From:
Sent: 29 October 2024 15:03
To: DC Admin
Subject: 2023/92966 - Demolition of existing dwelling and erection of 97 dwellings including formation - Land to the rear of, 271, Cliffe Lane, Gomersal, Cleckheaton, BD19 4SB

We object to this planning application based on the following points.

Drawing Number	152130-001	Rev	A
----------------	------------	-----	---

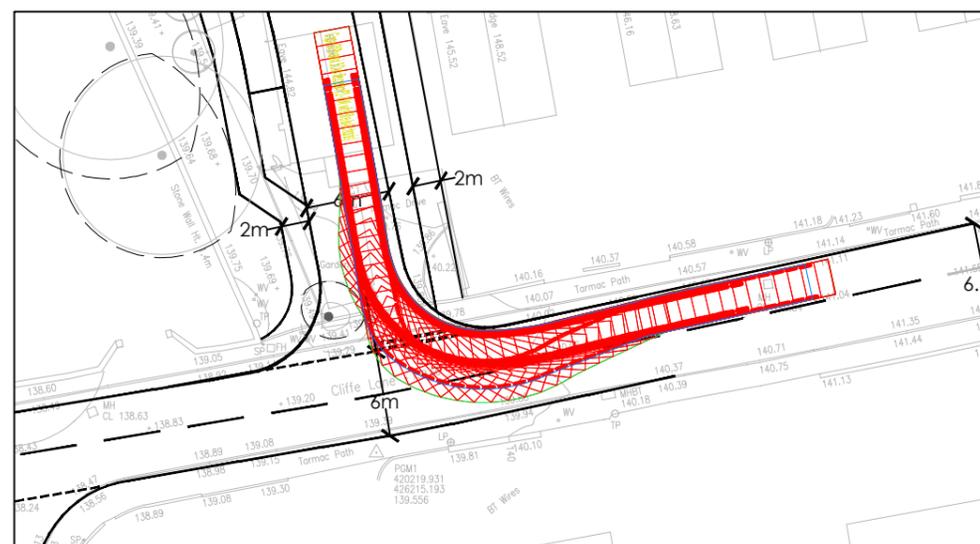
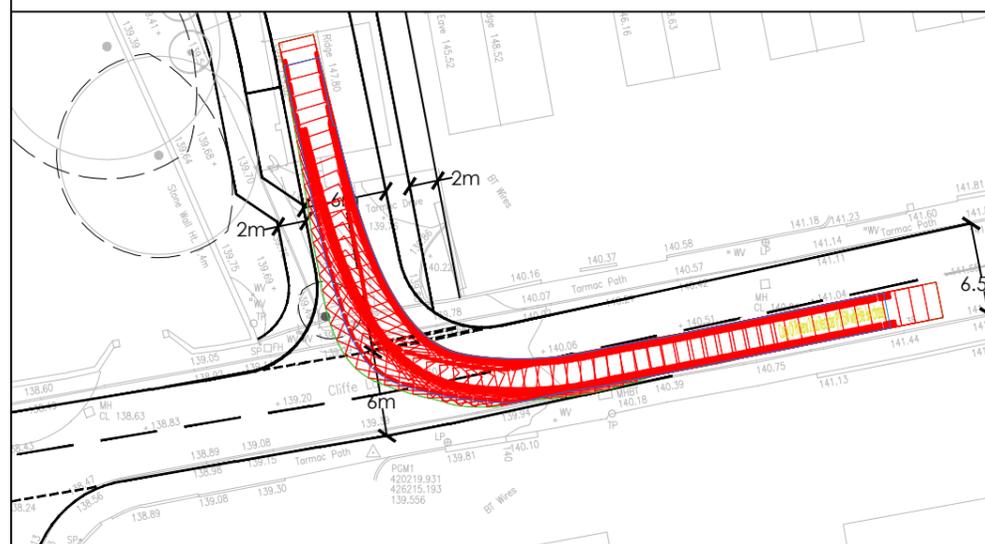
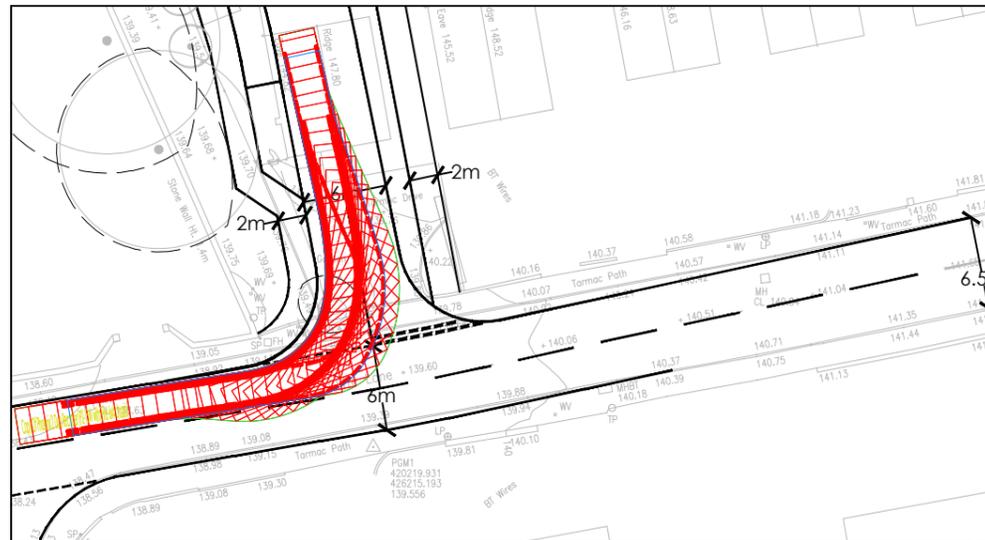
As consultation responses suggest, the planned site access has been designed based on the wrong type of (a smaller) refuse collection vehicle that what the council uses. This should be re-assessed and corrected. The information provided, and other comments, seem to suggest that the plan's access are unsuitable and dangerous for larger vehicles. This will further cause excessive congestion to Cliffe Lane and disturb residents and road users alike.
